KIRKLEES METROPOLITAN COUNCIL INVESTMENT & REGENERATION SERVICE

DELEGATED DECISION TO DETERMINE APPLICATIONS FOR LISTED BUILDING CONSENT

Reference No:	2024/65/92106/E
Site Address:	Wesley House, Huddersfield Road, Birstall, Batley, WF17 9AZ
Description:	Listed Building Consent for alterations to convert former offices to 21 apartments (within a Conservation Area)
Recommending Officer:	Nina Sayers

Officer Report

Plan : Proposed Elevations

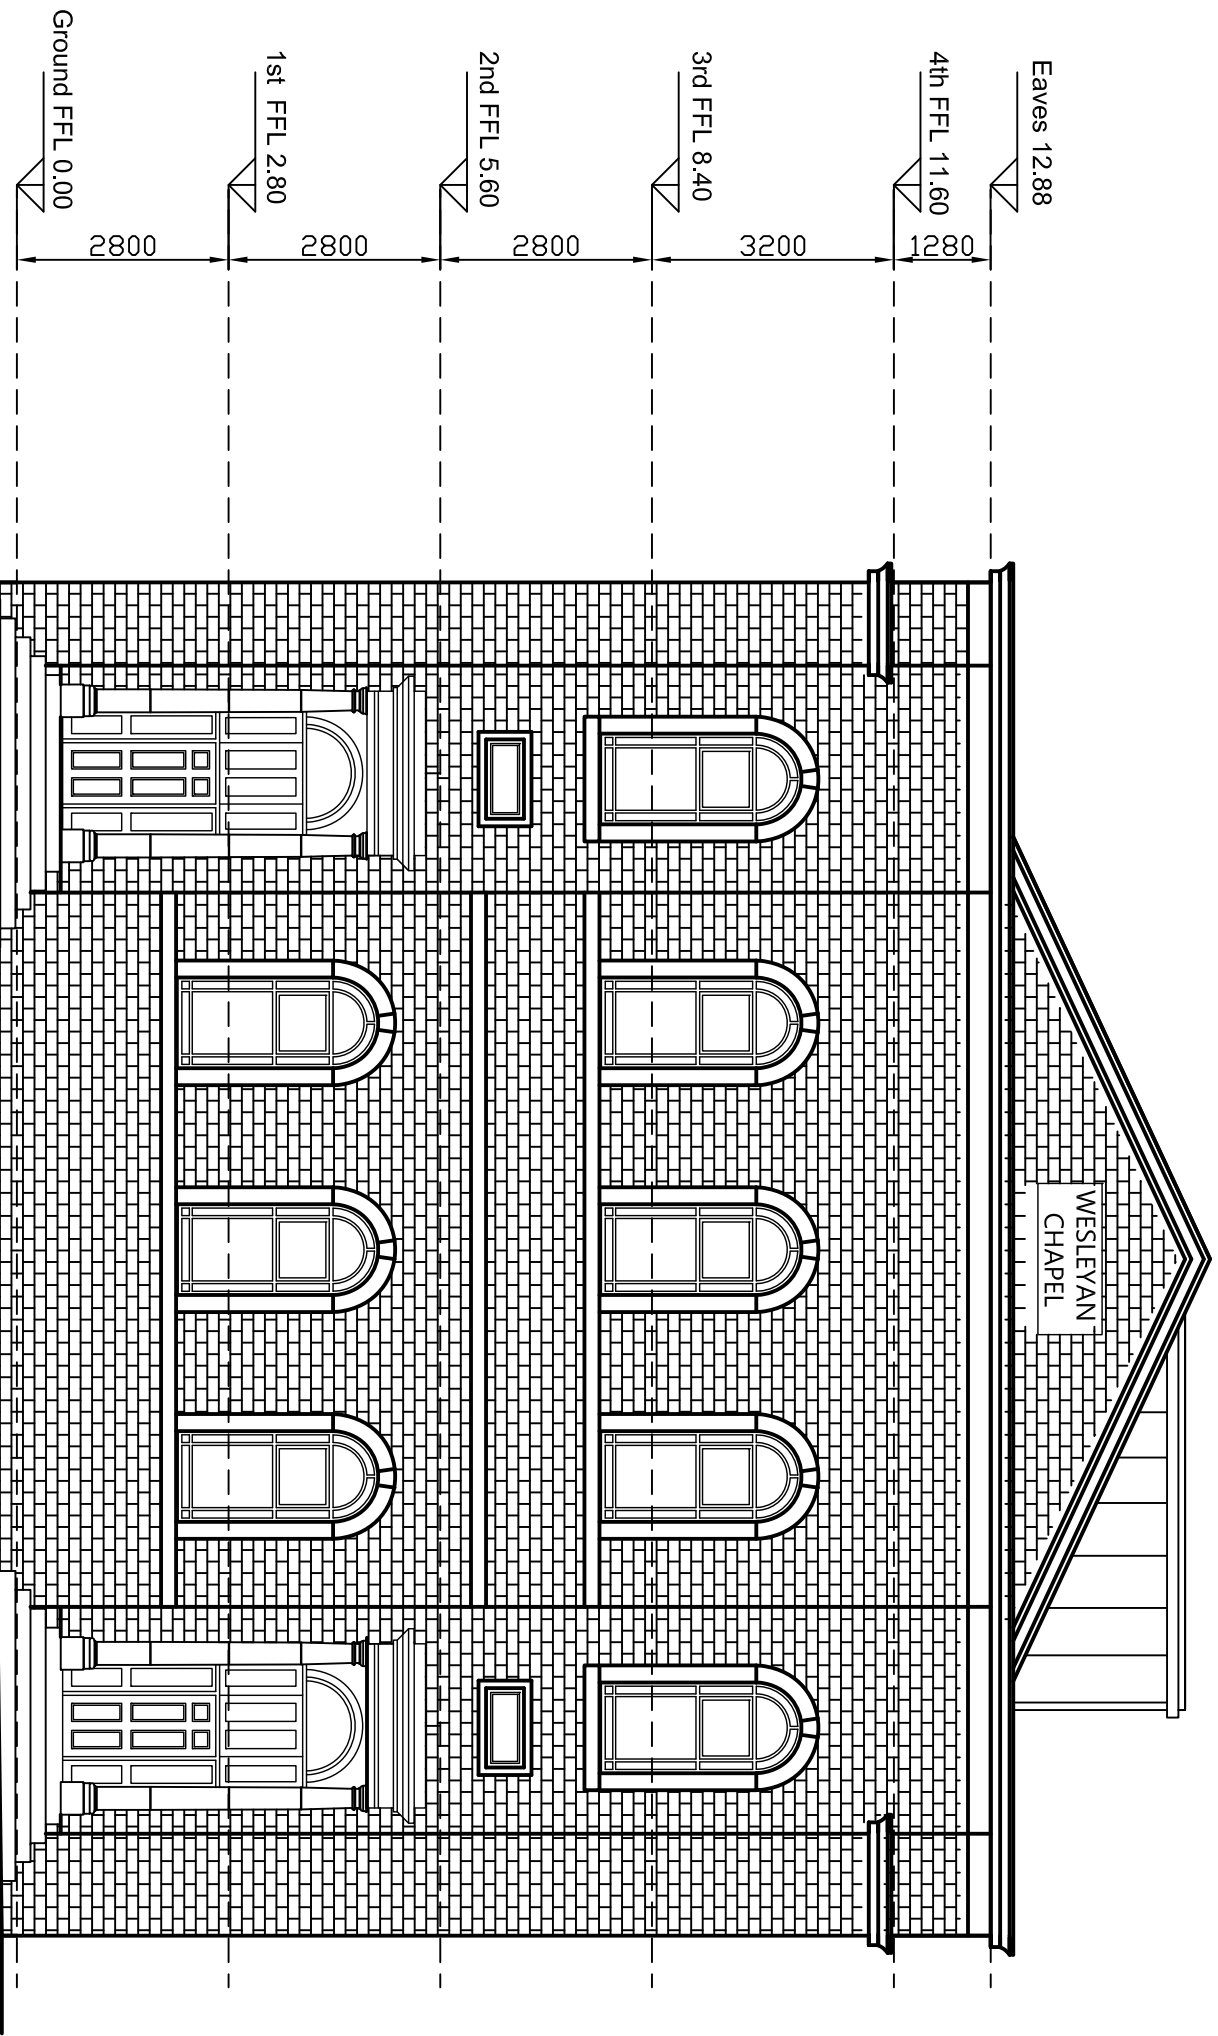
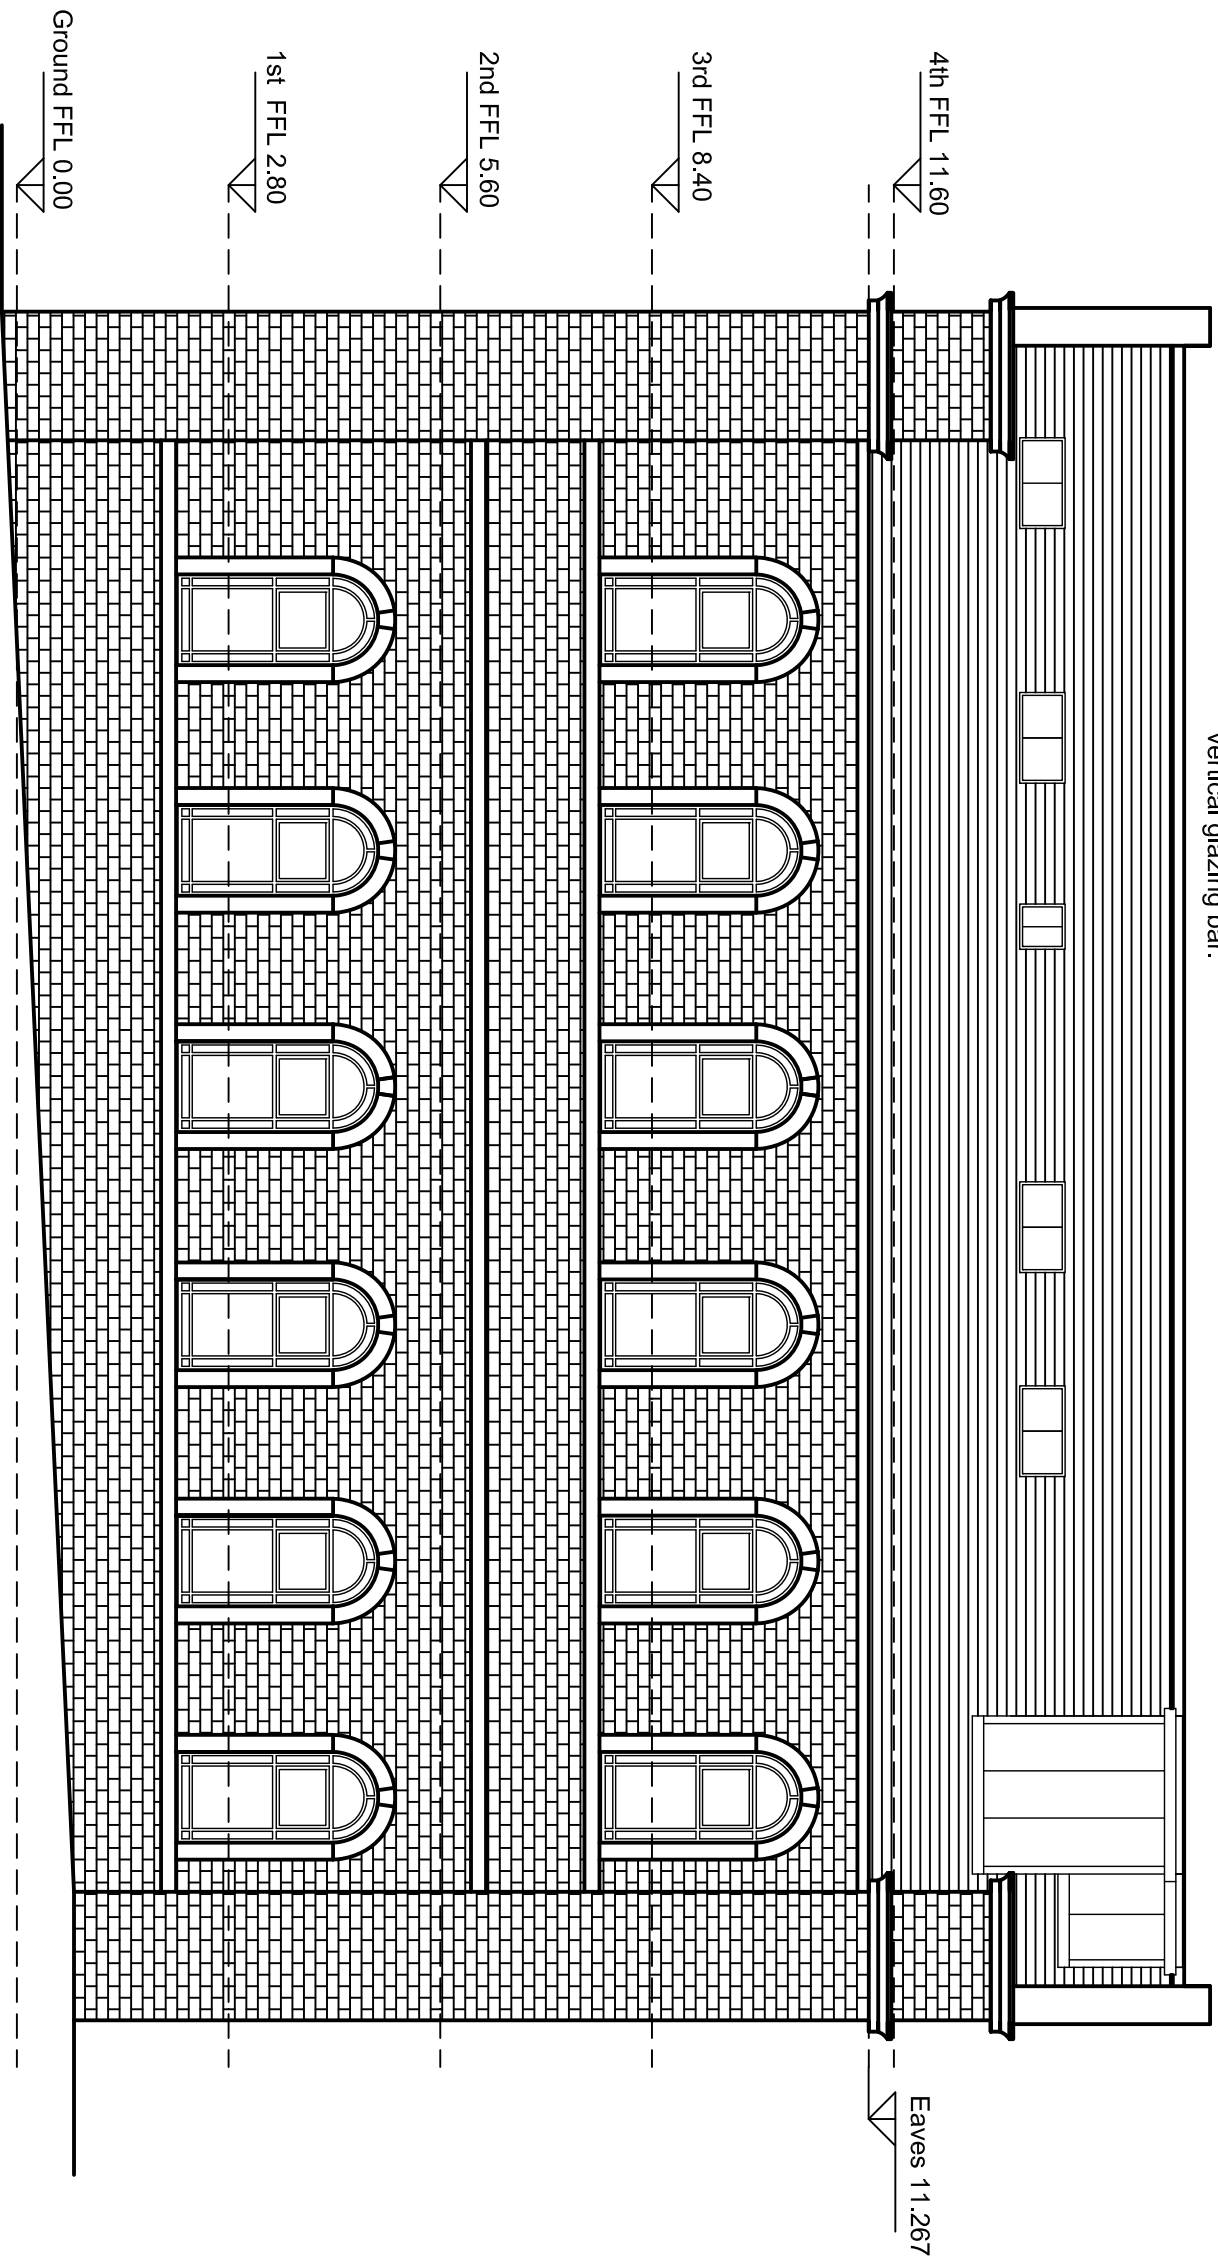
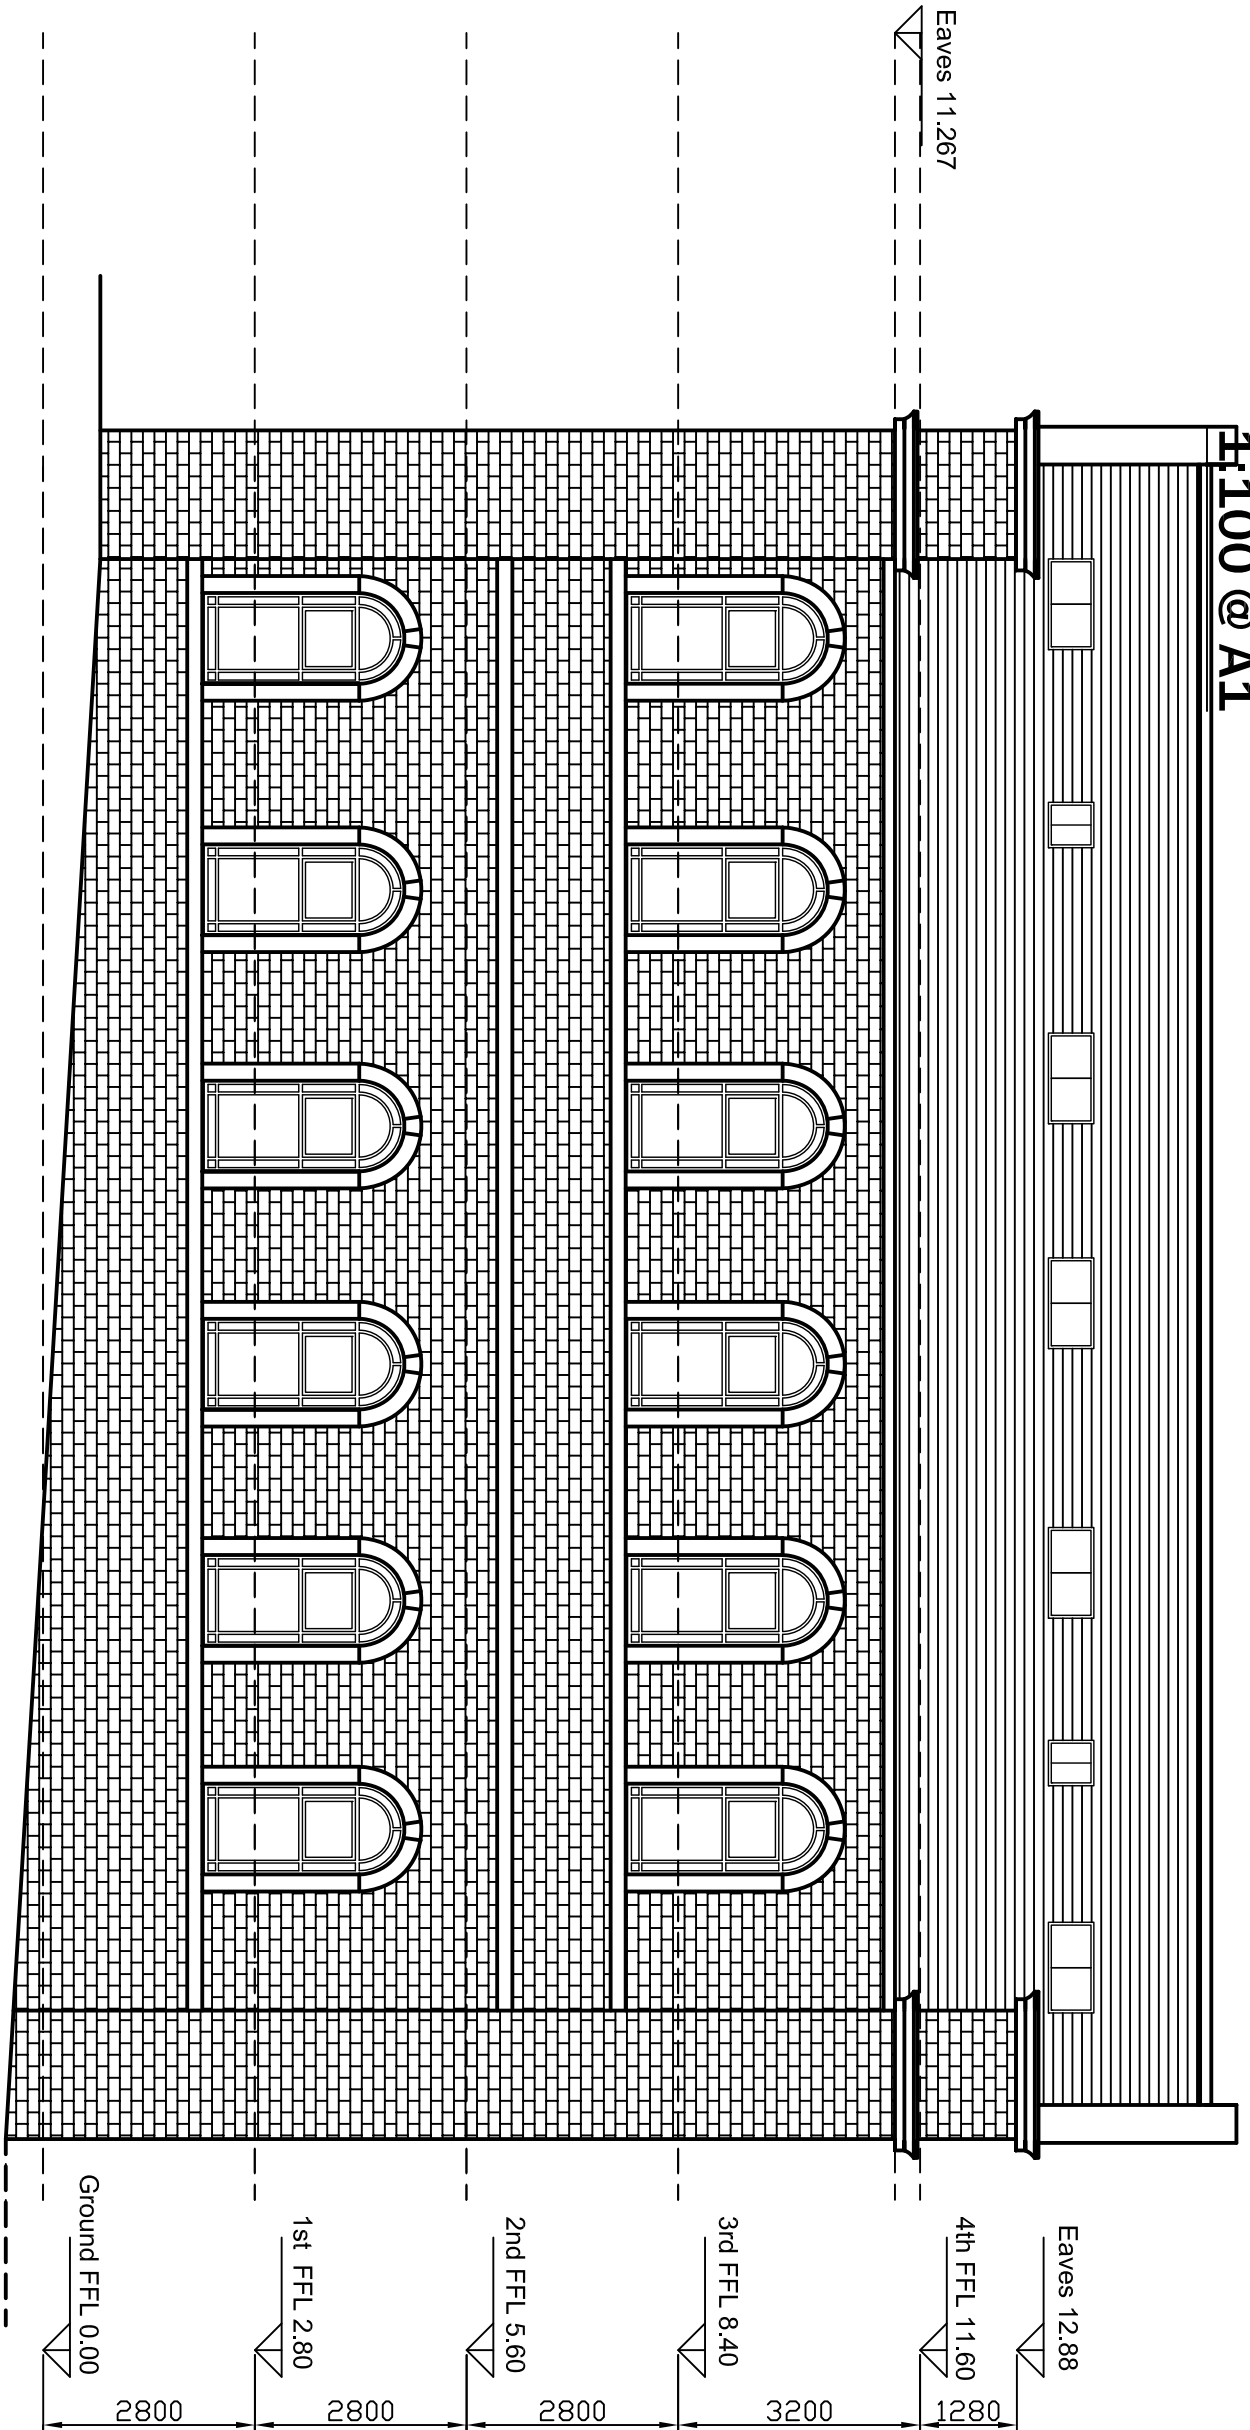
Initially the scheme proposed a lift shaft, which protruded out the roof face of the building, serving lift access to the fourth floor. Officers raised concerns regarding the impact of this on visual amenity and the listed building’s heritage value. As a result, amended plans were received which removed the protruding element whilst retaining the internal lift.
